from
**Southern
Water**

Our ref
PLAN-039202

Proposal: Demolition of existing dwelling and outbuildings and erection of 5 dwellings comprising 2 No 4 bed houses, 3 No 3 bed house (resubmission following Y/33/20/PL). This site is in CIL Zone 3 & is CIL Liable as new dwellings.

Site: Y/57/21/PL: - Sunnymead, North End Road, Yapton, BN18 0DL.

DATE	September 2020	DRAWN	MH
DRAWING NUMBER	20148-03	REVISION	B

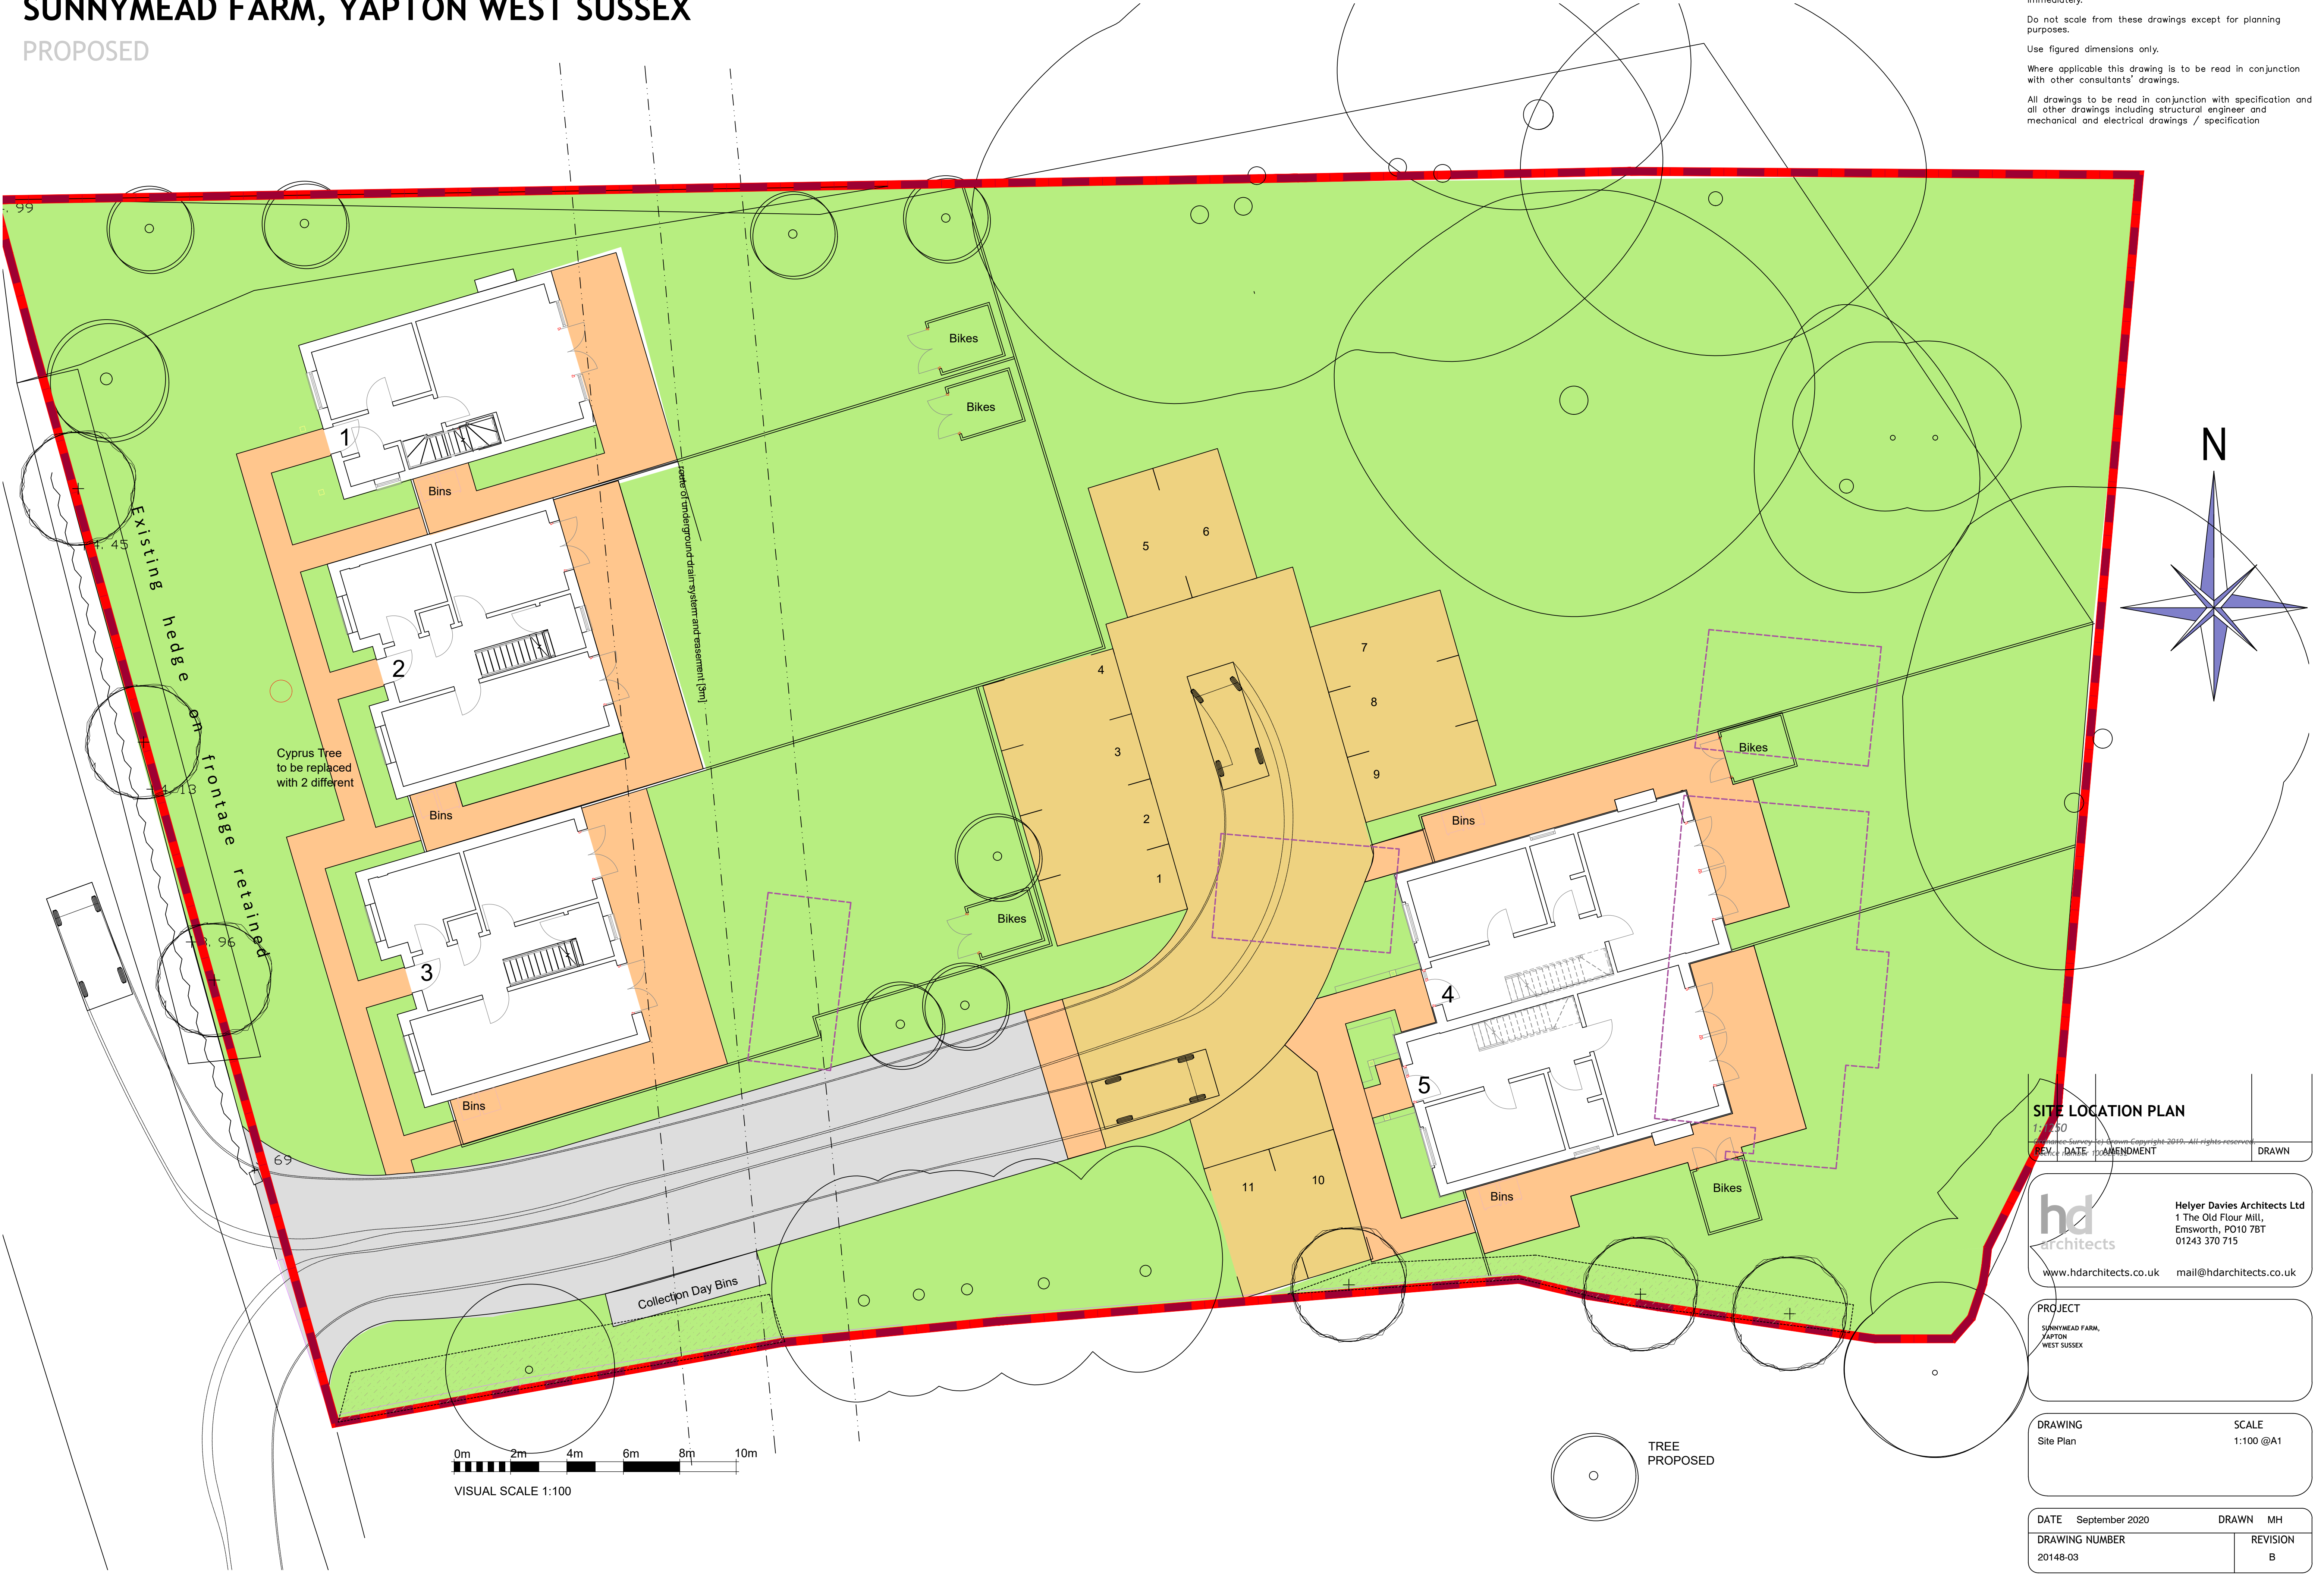
The submitted site plan (Drwg No. 20148-03 Rev B) shows 3 metres easement to the public foul sewer which is acceptable to Southern Water.
